Reference No: 2018/62/90677/W

Site Address: 98, Halifax Old Road, Birkby, Huddersfield, HD2 2RP

Description: Change of use and alterations to dwelling (Use Class C3) to form House of Multiple Occupation (5 bedrooms) (Use Class C4), installation of rooflights to front and rear elevation and window openings at semi-basement level (within a Conservation Area)

Officer Report

Project Title
proposed halifax old road elevation

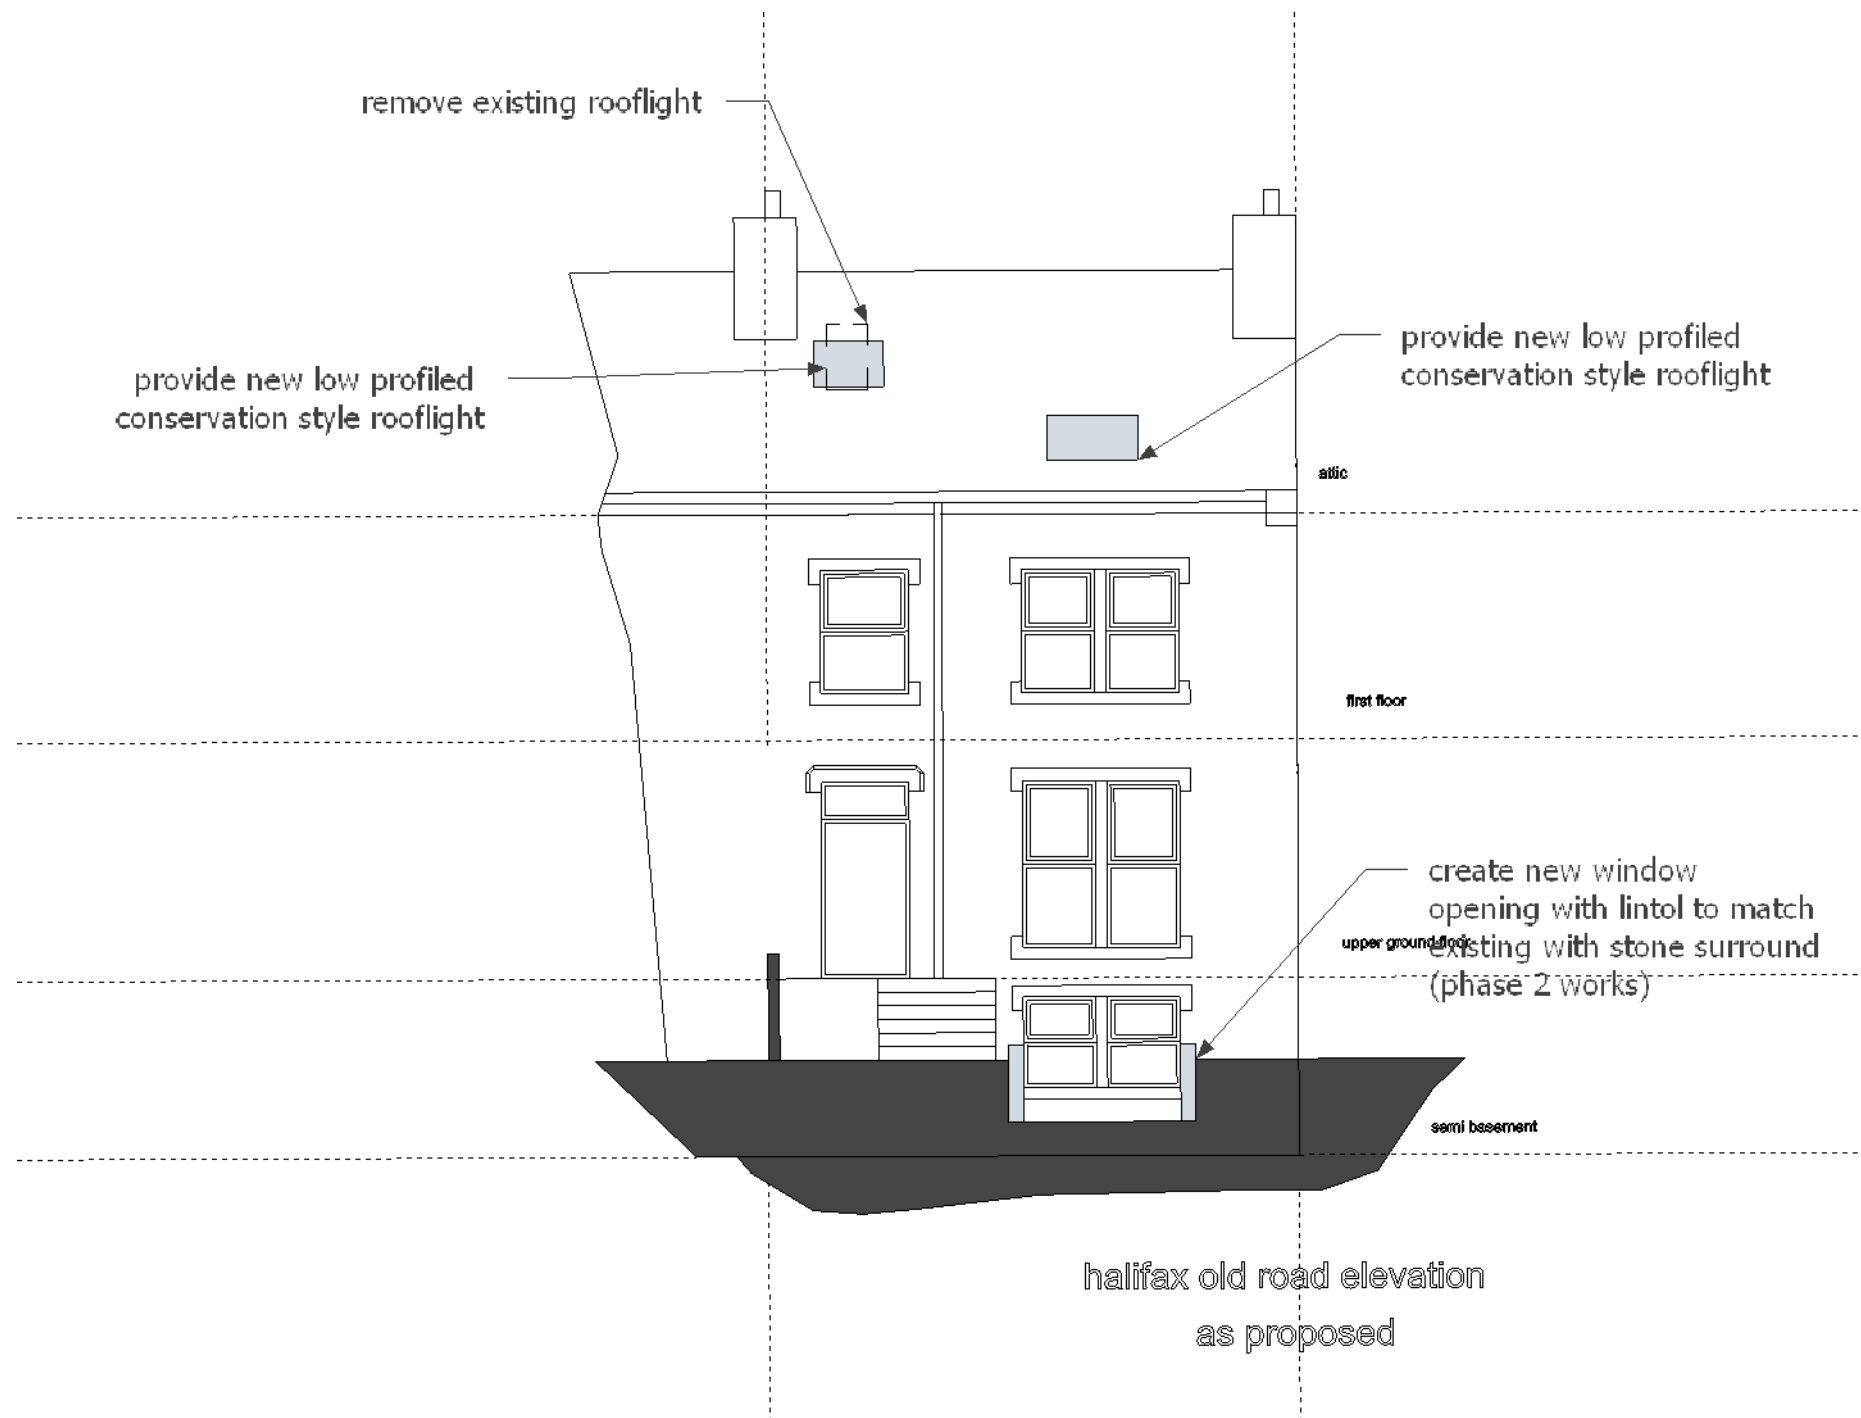
The proposed basement window and lightwell to the front elevation would not be overly obtrusive in my opinion and provided the window materials match the existing dwelling then there would not be any significant impact on the Conservation Area. The drawing indicates that the window is to have a lintel to match the existing windows and a stone surround.

3. The materials used in the construction of the new window opening to the front of the dwellinghouse shall in all respects match those found on the front of the existing building and shall thereafter be retained as such.

Drawn No.
109

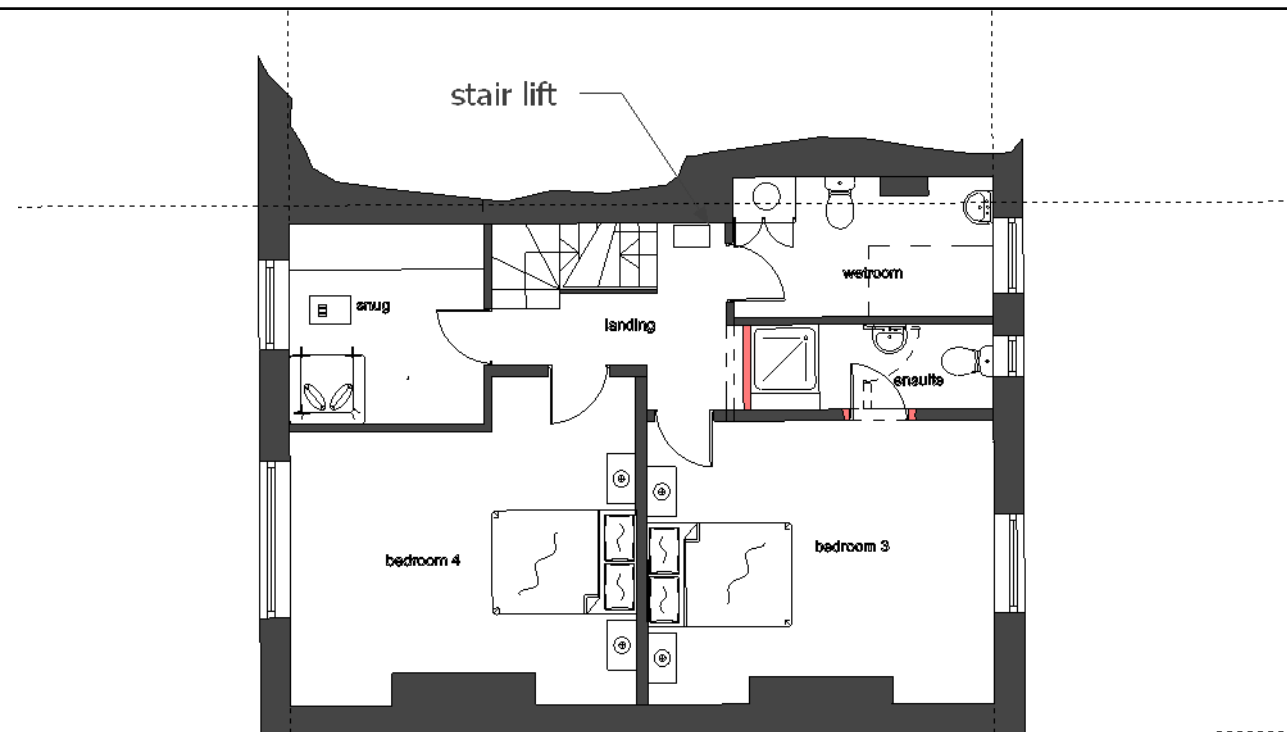
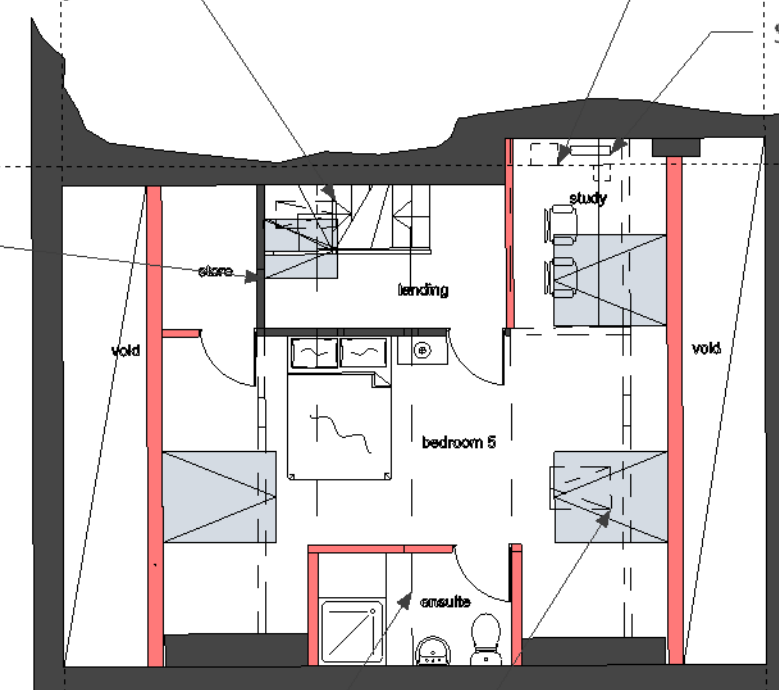
The rooflights are shown as being low profiled conservation type. There are two small rooflights on the dwelling that are to be removed. I do not have any concerns with the rooflights.

4. The rooflights to the front and rear of the dwellinghouse shall be of conservation type and retained as such.
